**Our Case Number:** ABP-318446-23

**Re:** Proposed construction of Coumnagappul Wind Farm consisting of 10 no. turbines and associated infrastructure.  
In the townlands of Coumnagappul, Carrigbrack, Knockavanniamountain, Barricreemountain Upper and Glennaneanemountain, Skeeheans, Lagg, Co. Waterford. ([www.coumnagappulwindfarmSID.ie](http://www.coumnagappulwindfarmSID.ie))

**Re: An Bord Pleanála Case Reference PA93.318446**

## **AMENDED REFERRAL RESPONSE**

**WATERMAIN UNDERCROSSING**

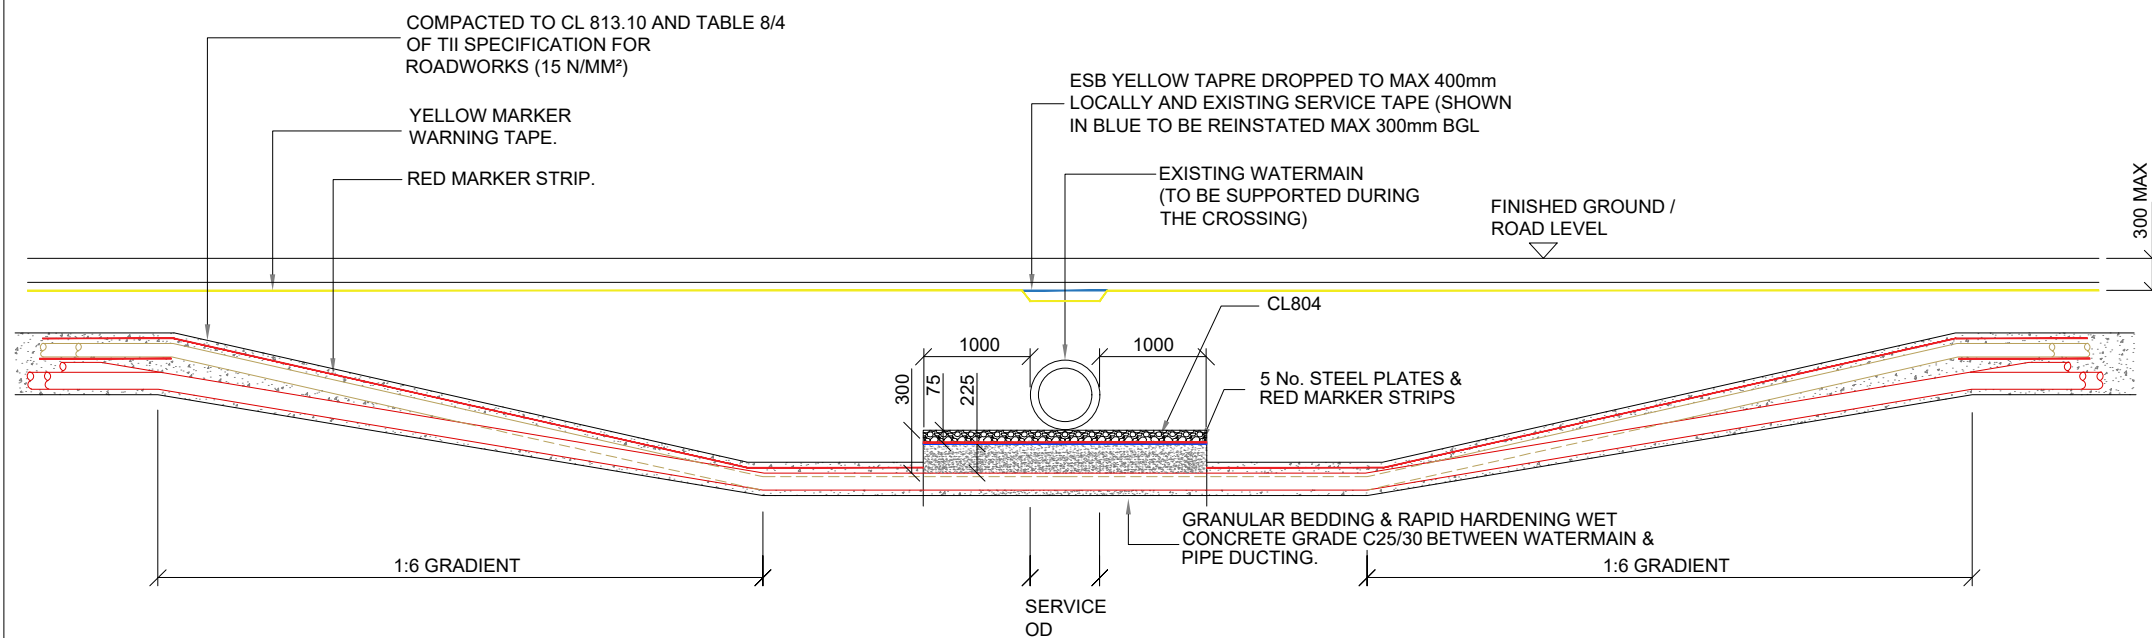
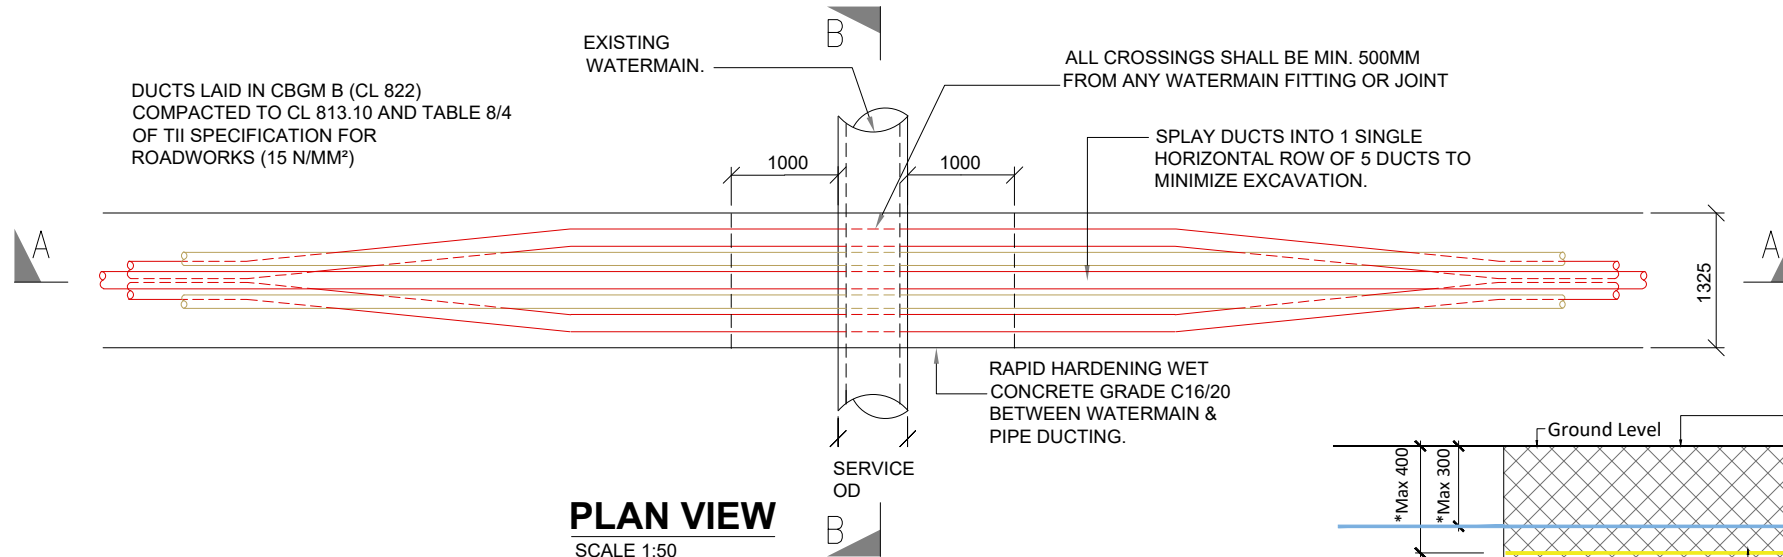
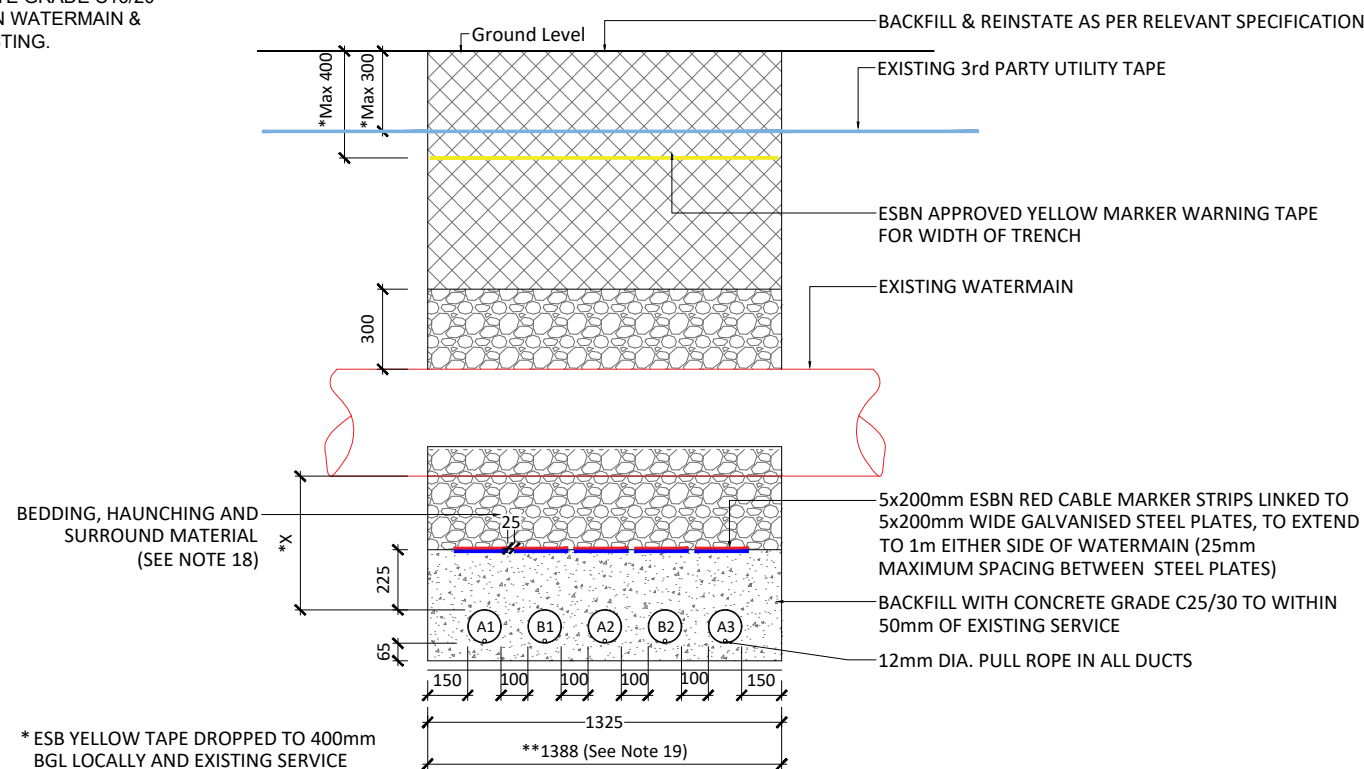
There are number of UÉ watermains and pipes along the proposed 22.47km underground cabling route which will be impacted by the proposed development. Acknowledging that UÉ was consulted at EIAR scoping stage, the applicant has not engaged with UÉ regarding the proposed underground cabling that is proposed under, over and in close proximity to the existing Uisce Éireann infrastructure. No plans or

details showing the number or locations of the overlap with UE infrastructure has been submitted.

The proposed 110kv underground cable is significant infrastructure and any interaction with public watermains and/or infrastructure needs to be carefully considered in order to ensure the public assets are adequately protected.

Structures or works over or in close proximity to UÉ infrastructure that may inhibit access for maintenance or endanger structural or functional integrity of the infrastructure are not permitted and separation distances shall be in accordance with the UÉ Codes of Practice and Standard Details.

UÉ have no objection in principle with building under UÉ infrastructure provided the assets are protected during the construction & operation phases of the development and that adequate separation distances are provided. However, UÉ cannot support proposals to cross above UÉ assets without sufficient, clear and detailed information.

Where building near / building over / diversions of existing UÉ assets are proposed, the associated designs need to be agreed with the UÉ Diversions team, a Confirmation of Feasibility must be issued by in the first instance UÉ before planning permission is granted.

In the context of above, UE requests that the applicant is required to submit a Confirmation of Feasibility to the UÉ Diversions team in order to assess the interactions with public water infrastructure. The Confirmation of Feasibility should be submitted to An Bord Pleanála as a response to this further information request.
